From: stephen jupp [REDACTED]
Sent: 11 May 2018 08:38
To: Anita Gardner
Cc: Ben Reeder
Subject: Re: FG/48/18/DOC Onslow Caravan Park, Ferring

The Drainage Engineer has stated relating to Condition 4 Drainage:

DRAINAGE PLAN - PLANNING
CONDITION 4

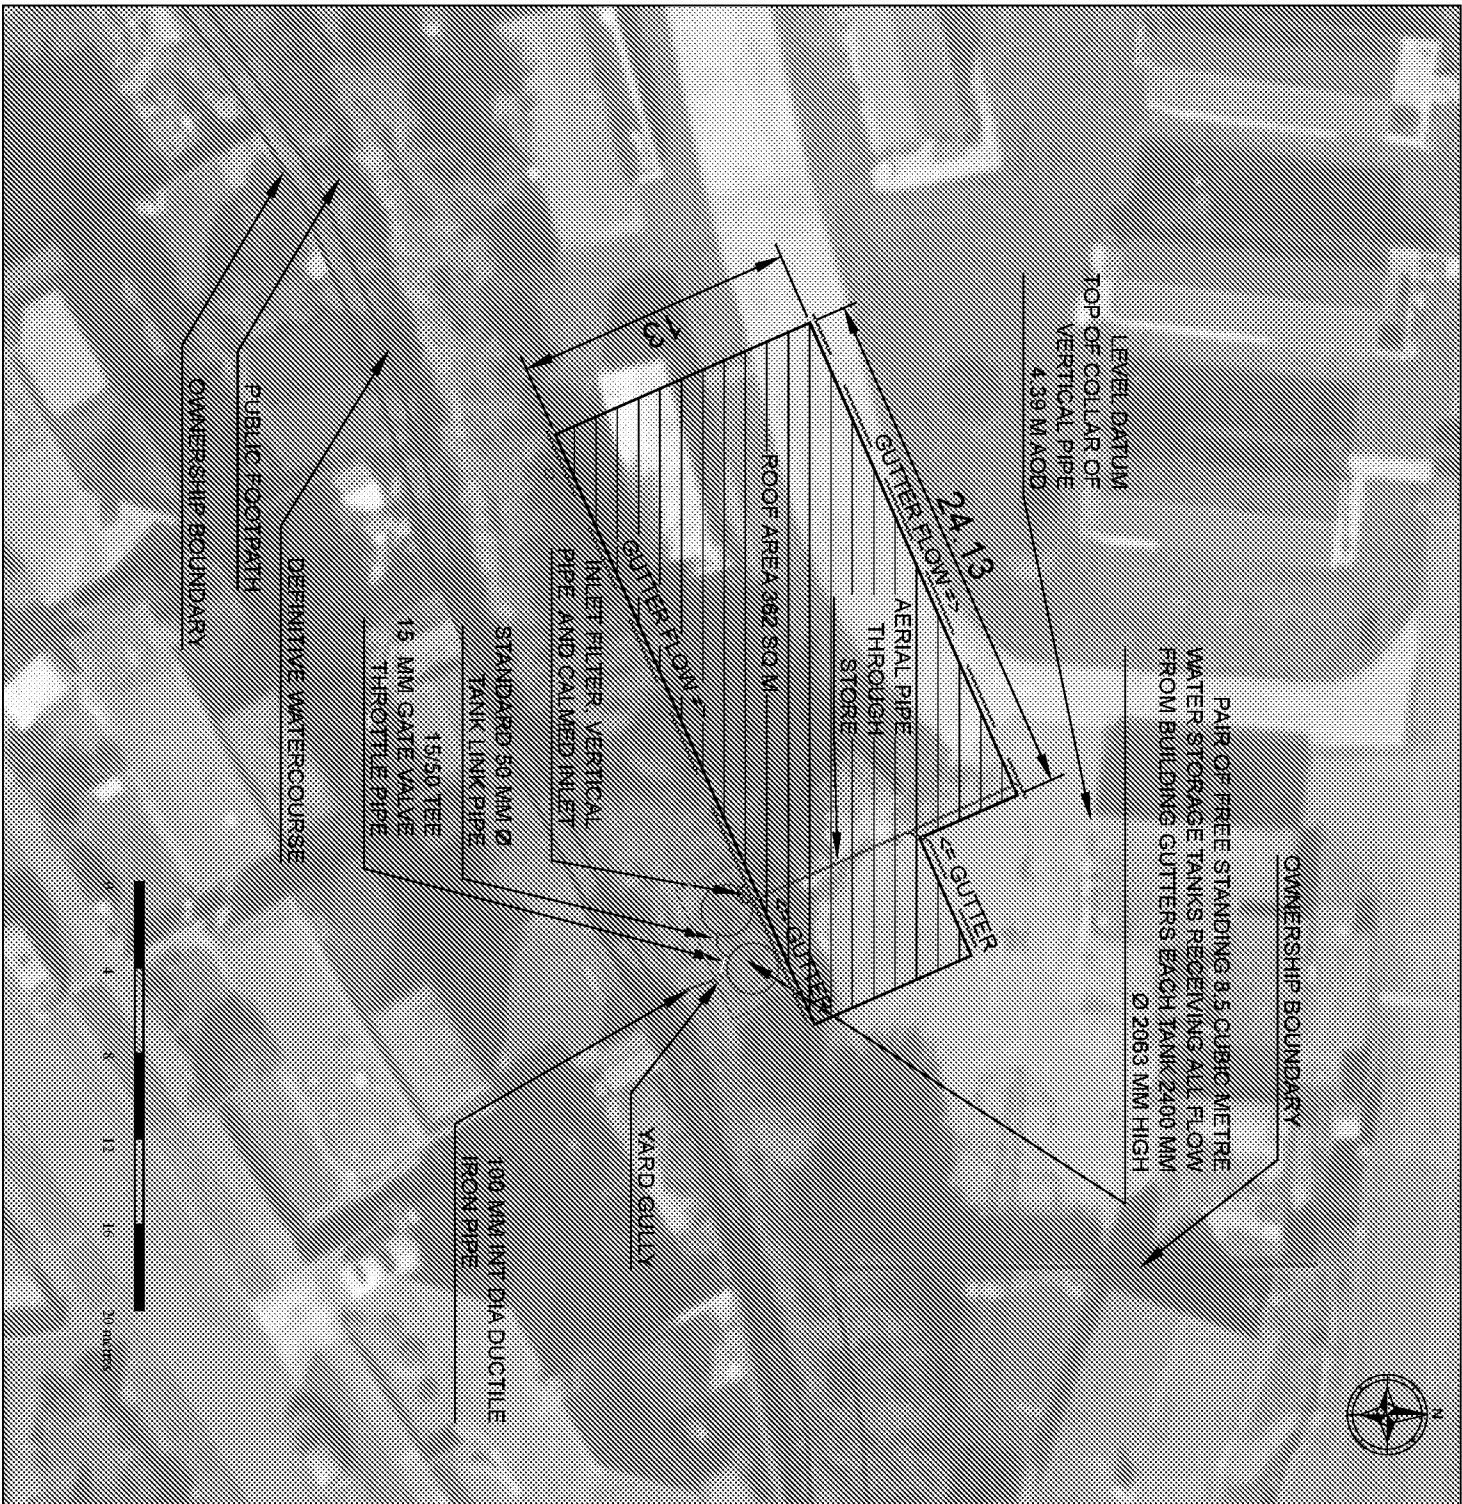
- It is noted that only a 20% allowance for climate change has been included in the design of the surface water drainage system. This needs to be increased to 30% in line with the condition applied. THE 20% ALLOWANCE ACCORDS WITH PLANNING PRACTICE GUIDANCE FOR THE LIFETIME OF THE DEVELOPMENT PROPOSED, AND ALSO WITH THE CENTRAL ALLOWANCE FOR RESIDENTIAL DEVELOPMENT. 30% IS NOT JUSTIFIED.

- Storm durations from and including 15 minutes need to be used. THE CALCULATION INVESTIGATED STORM DURATIONS AT TEN MINUTE INTERVALS FROM 10 MINUTES TO 72 HOUR DURATION. ONLY SELECTED DETAILS ARE REPORTED, THE CRITICAL DURATION IS QUOTED TO THE NEAREST TEN MINUTES.

- The restriction size of 20mm is of concern regarding the possibility of blockage. It is recommended that a mesh or similar is installed within each tank at the face of the outlet. THE INLET STRAINER IS SUPPLIED TO PREVENT LARGE PARTICLES ENTERING THE TANKS. FLOW RATES THROUGH THE OUTLET ARE SO LOW THAT IF GROWTH OCCURS WITHIN THE TANKS, IT WOULD NOT TEND TO BE DRAWN TOWARDS THE OUTLET, WHICH HAS THE ABILITY TO PASS 15 MM PARTICLES. IF A BLOCKAGE WERE TO OCCUR, IT WOULD SPOTTED QUICKLY AND WOULD BE EASY TO REMOVE. WHEREAS THE TEE COULD BE CHANGED AND A 1 1/2" BSP STRAINER ADDED, ALLOWING EASY MAINTENANCE, SUCH A STRAINER IS LIABLE TO BLOCKAGE WITH SMALL PARTICLES. THEREFORE NO STRAINER IS RECOMMENDED. A MESH SCREEN WITHIN THE TANKS AS SUGGESTED WOULD BE VERY DIFFICULT TO MAINTAIN AND THUS ALSO IS NOT RECOMMENDED.

- It is currently proposed that the outlet to the existing ditch will be formed by a paving slab. This is not acceptable, we require a formal headwall to be formed using concrete bags or brickwork. With full construction detail drawings to be supplied and approved by us. THE OUTLET PIPE IS DUCTILE IRON WITH A FLAP ATTACHED. AS SUCH THE OUTLET IS RESILIENT TO DAMAGE AND BARELY ANY DISTURBANCE OF THE BANK WILL OCCUR. A HEADWALL IS ENTIRELY UNNECESSARY, THE PROPOSED PAVING SLAB CAN BE OMITTED.
- Full construction details will be required including the gully/headwall, any manholes, and silt traps. DRAWING 100A ALREADY SHOWS EVERY DETAIL NECESSARY TO BUILD THE UNDERGROUND DRAINAGE. NO OTHER DETAIL COULD BE REQUIRED.
